Our Case Number: ABP-314724-22

Re: Railway (Metrolink - Estuary to Charlemont via Dublin Airport) Order [2022]
Metrolink. Estuary through Swords, Dublin Airport, Ballymun, Glasnevin and City Centre to Charlemont, Co. Dublin

Metro Link Railway Works Order Submission

16 January 2023

TUNNEL ALIGNMENT
SAINT STEPHEN'S GREEN – CHARLEMONT
RO APPLICATION VS DEEPER VERTICAL ALIGNMENT OPTION

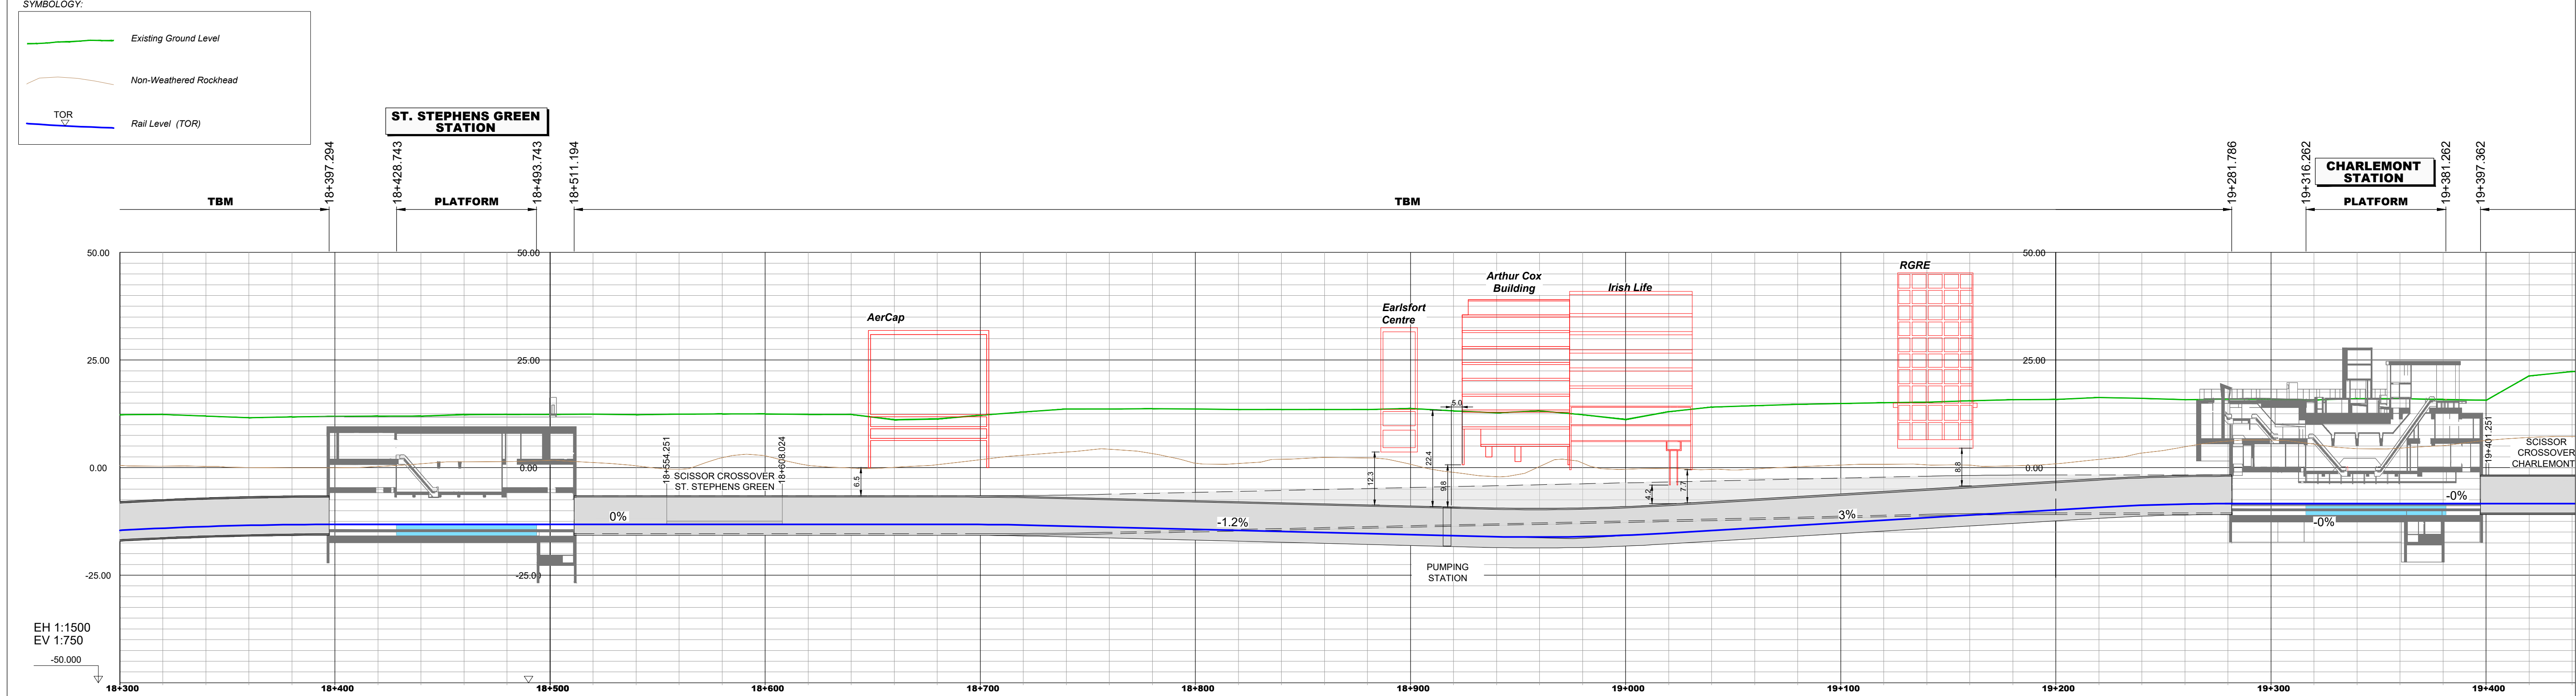
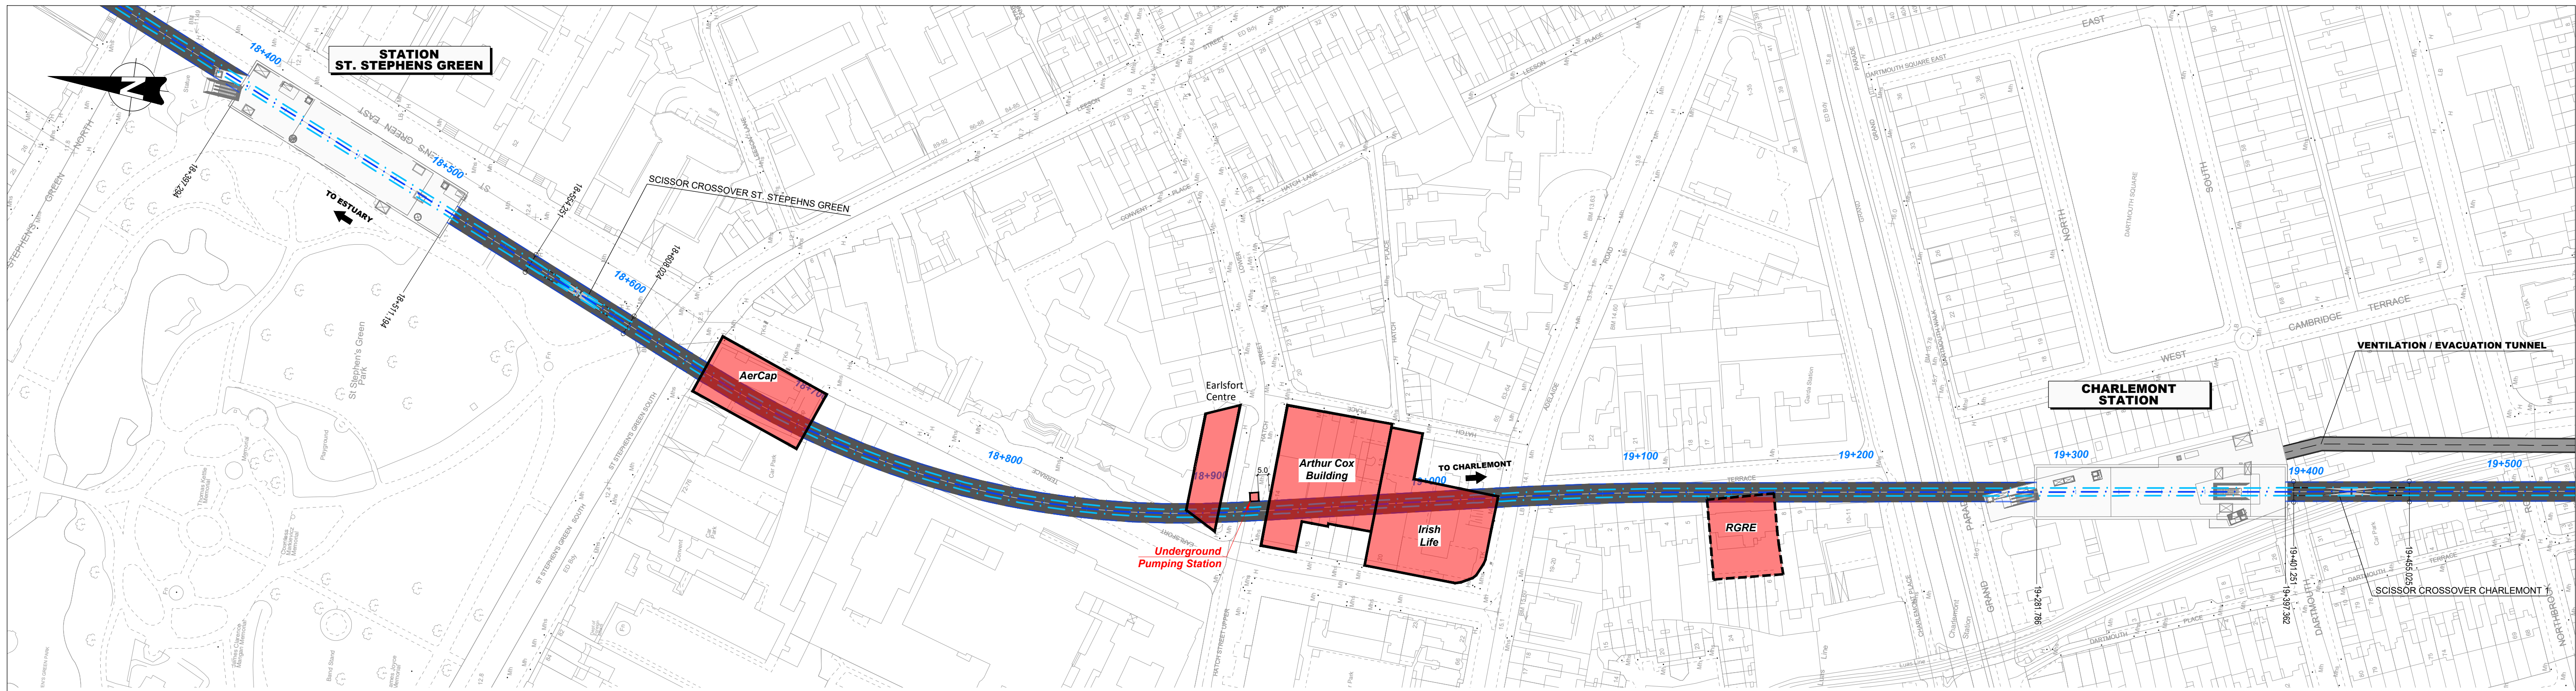
The reversing section at Charlemont appears to be able to store only a single train while allowing one track for reversing. As the metro will be fully automated it would be operational helpful to be able to store several trains at Charlemont to dynamically manage frequency so the stub section would need to be 140-150m long not that current ~70m.

Slide 1 – Tara Station Location Options

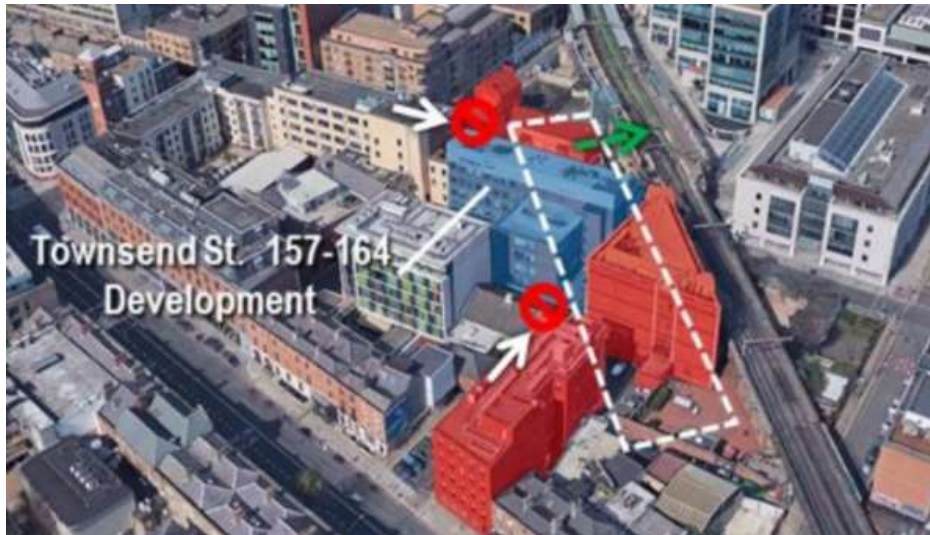
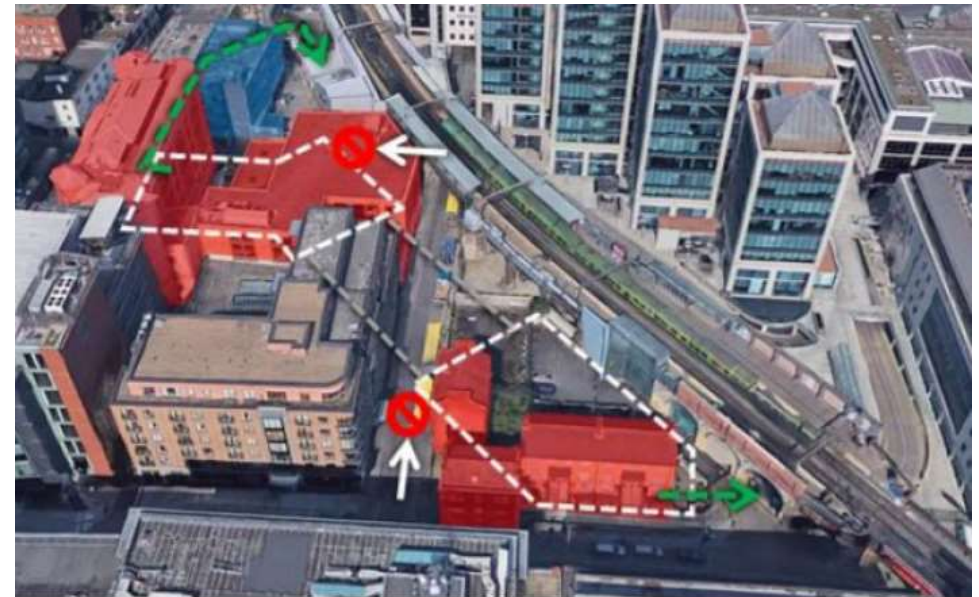
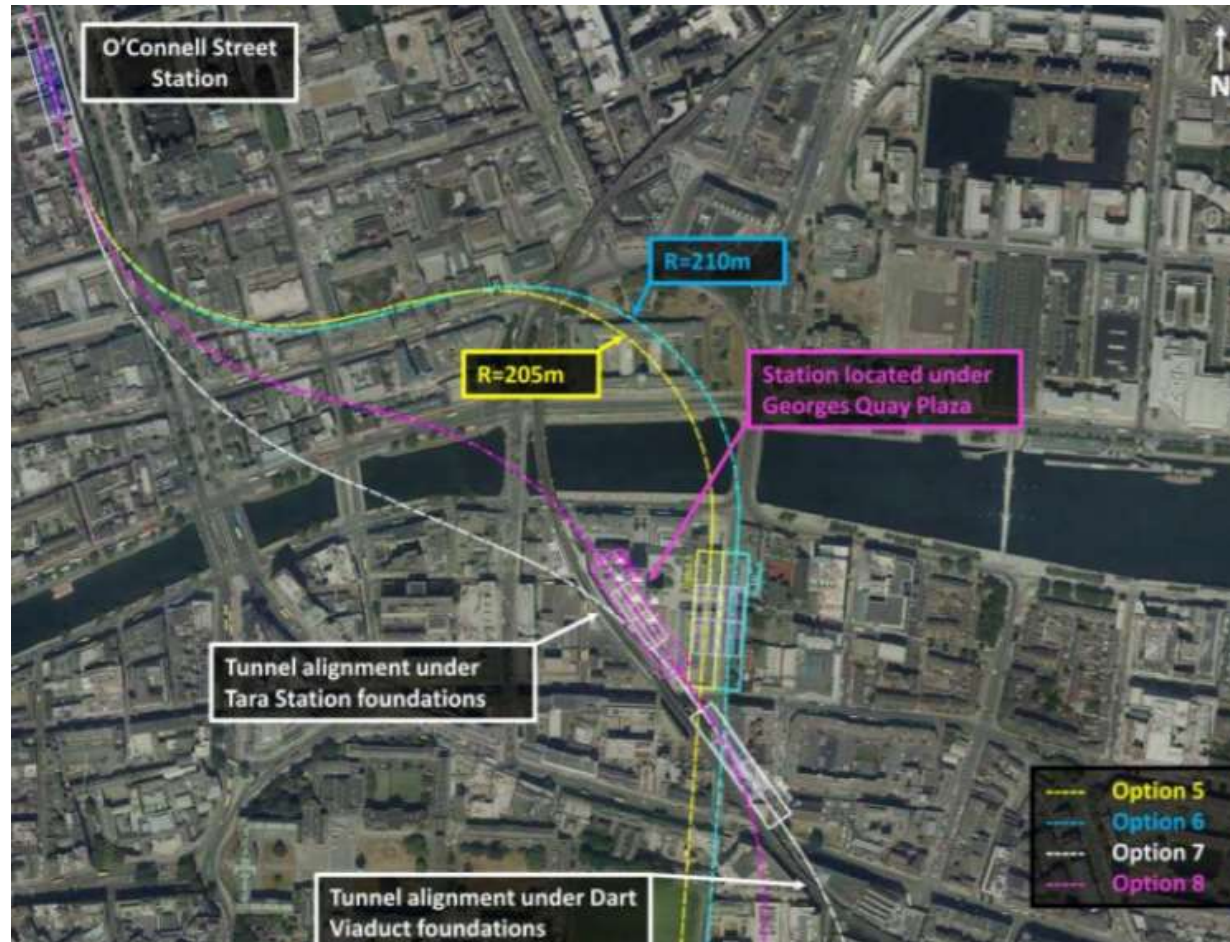
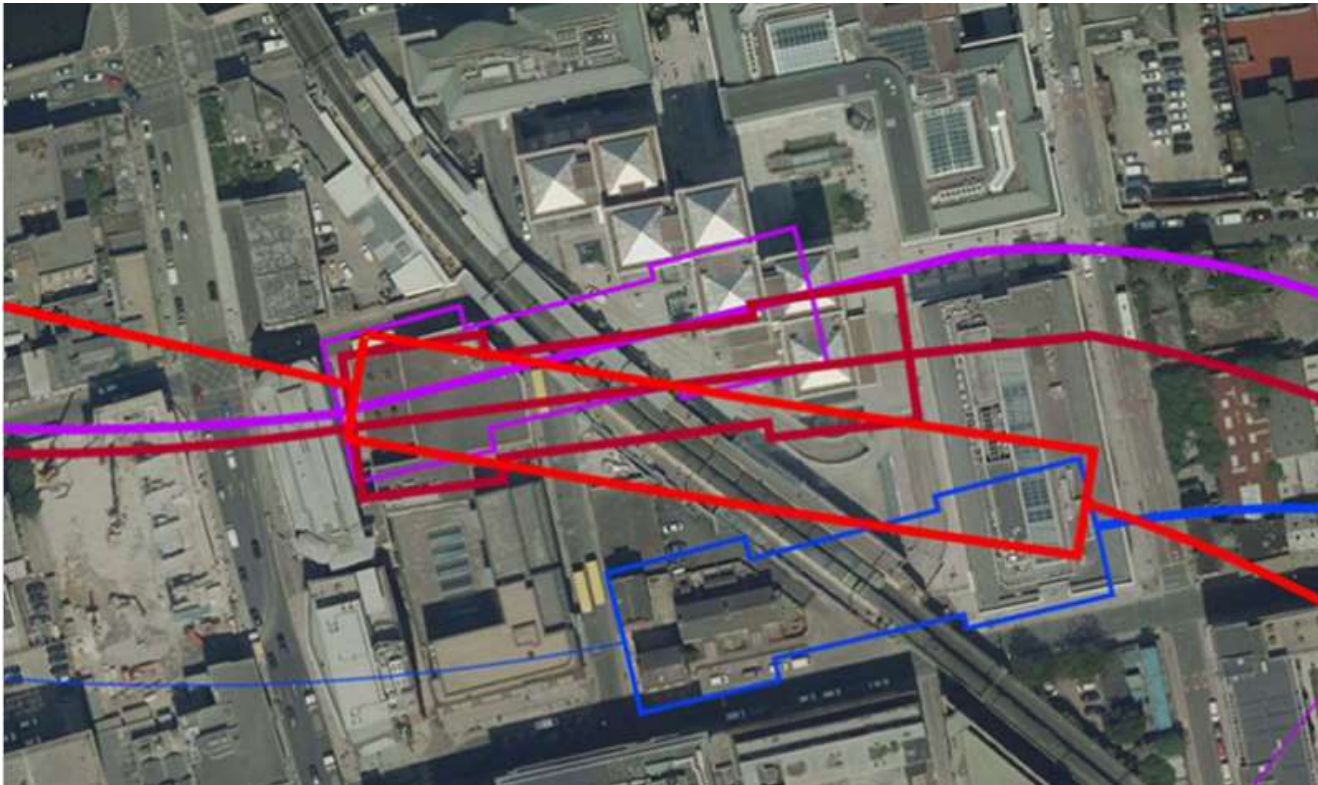
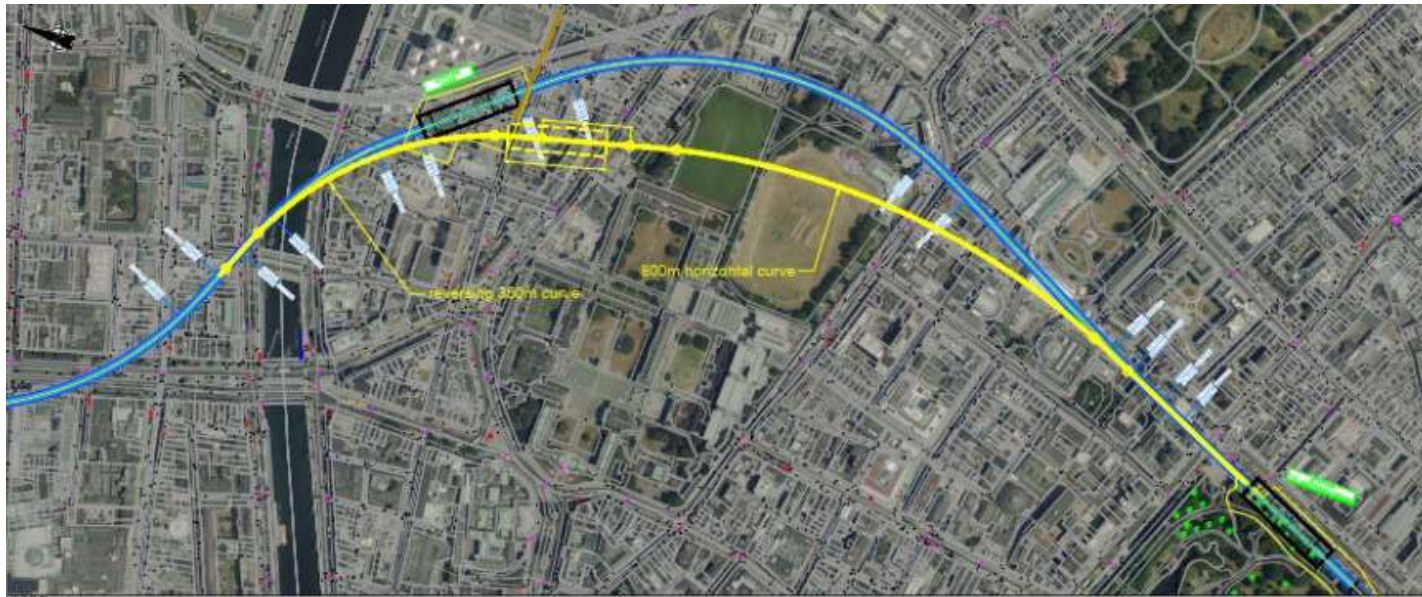
Zero integration with Irish Rail at Tara Street. Given the curved platform at Tara Street it is a poor location for high volume interchange of passengers. No amount of work will address the Irish Rail platform interface issues at Tara Street.

Stating it is future work for Irish Rail is not acceptable, everything needs to be included in the works order to avoid issues and to minimise the duration of construction on site.

With the long term plan to build DART underground, Glasnevin and St Stephens Green would provide connections to all rail routes and thus Tara Street would not be needed at all as an interchange.

There are significant long term benefits to not connecting at Tara Street

1. Remove one station and provide a more direct alignment cost and construction time saving
2. Shorter alignment and fewer stops, fewer trains required to maintain frequency
3. Shorter alignment and fewer stops, shorter end to end journey time which drives passenger demand and modal transfer
4. Eliminates significant and disruptive residential and commercial property demolition
5. Reduced construction impact on city
6. Eliminates subsidence risk or other construction risk on Loop line viaduct, see recent incident in Berlin at Alexanderplatz on line U2 where nearby construction has shut the line as an example.

Charlemont LUAS stairs & lift connection 2024

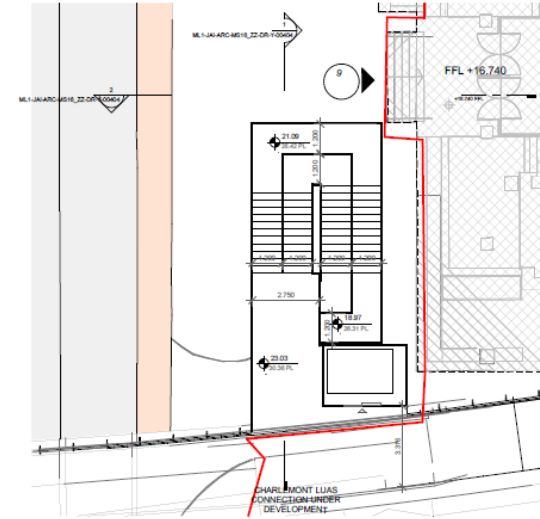
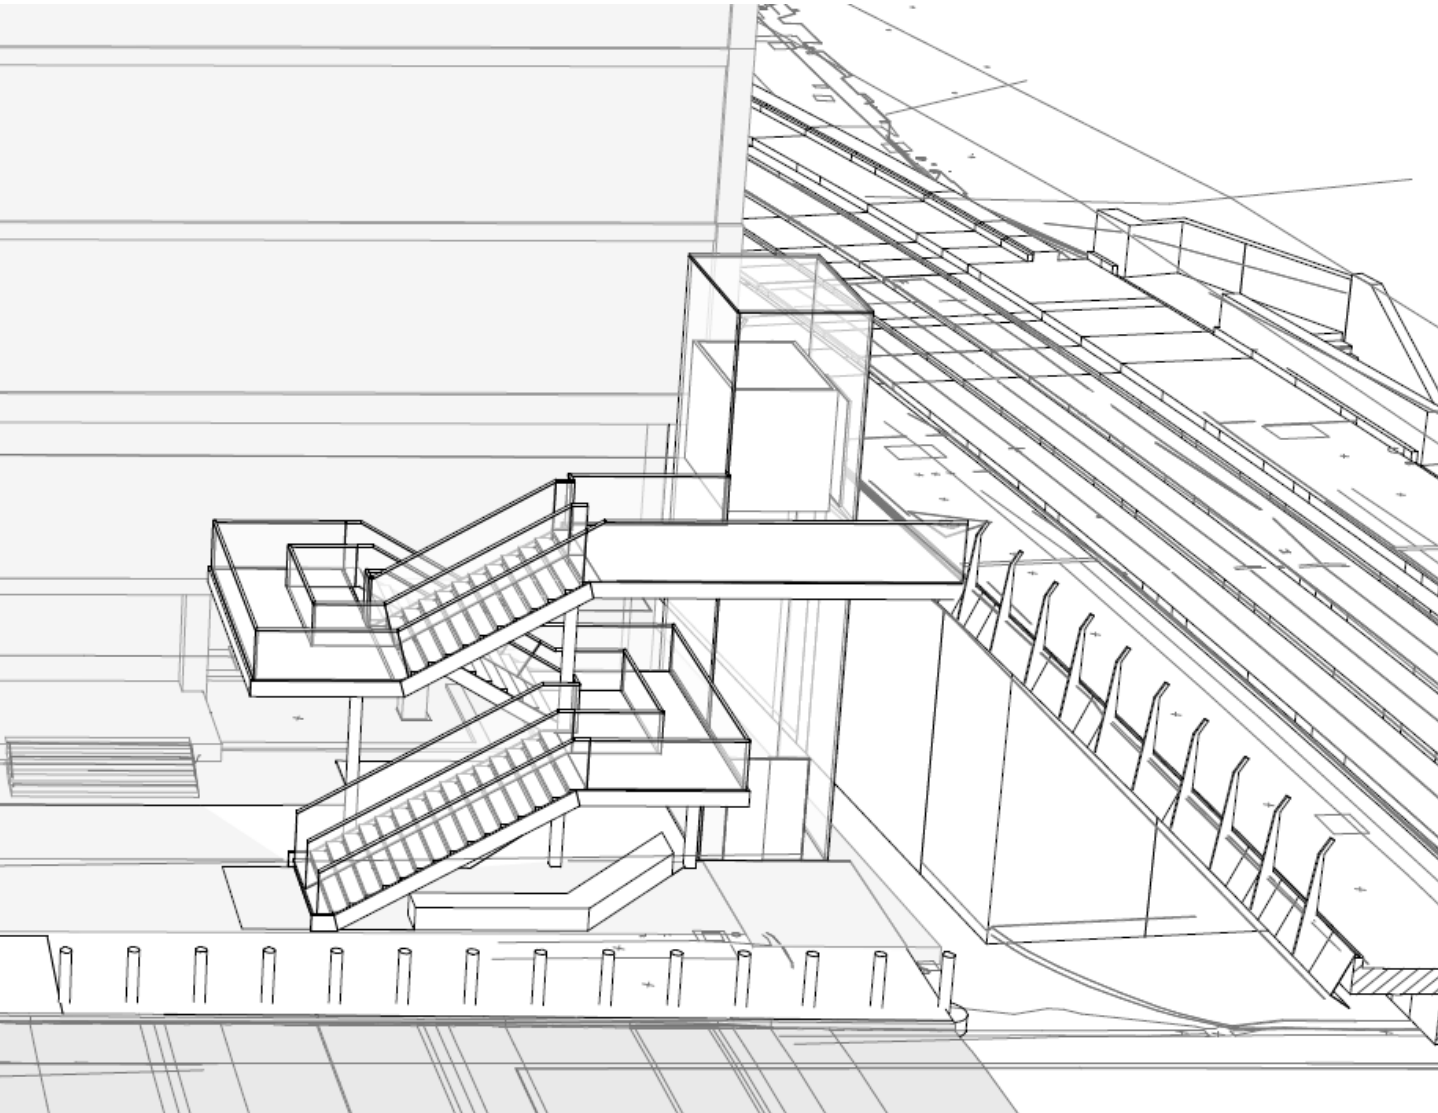
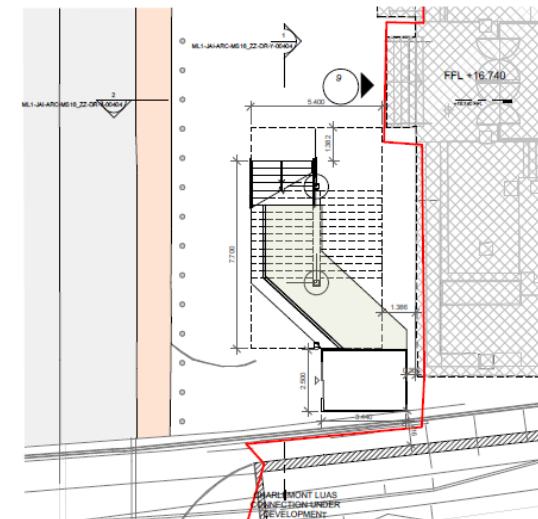
Proximate is not integrated. Single flight of stairs to provide connection to Luas at Charlemont is insufficient in capacity terms given we expect a large turnover of passengers at this location given lack of integration at St Stephens Green.

Dedicated separate lifts and stairs should be provided for each Luas platform side to Metro station mezzanine level below, avoiding the need to walk on the street.
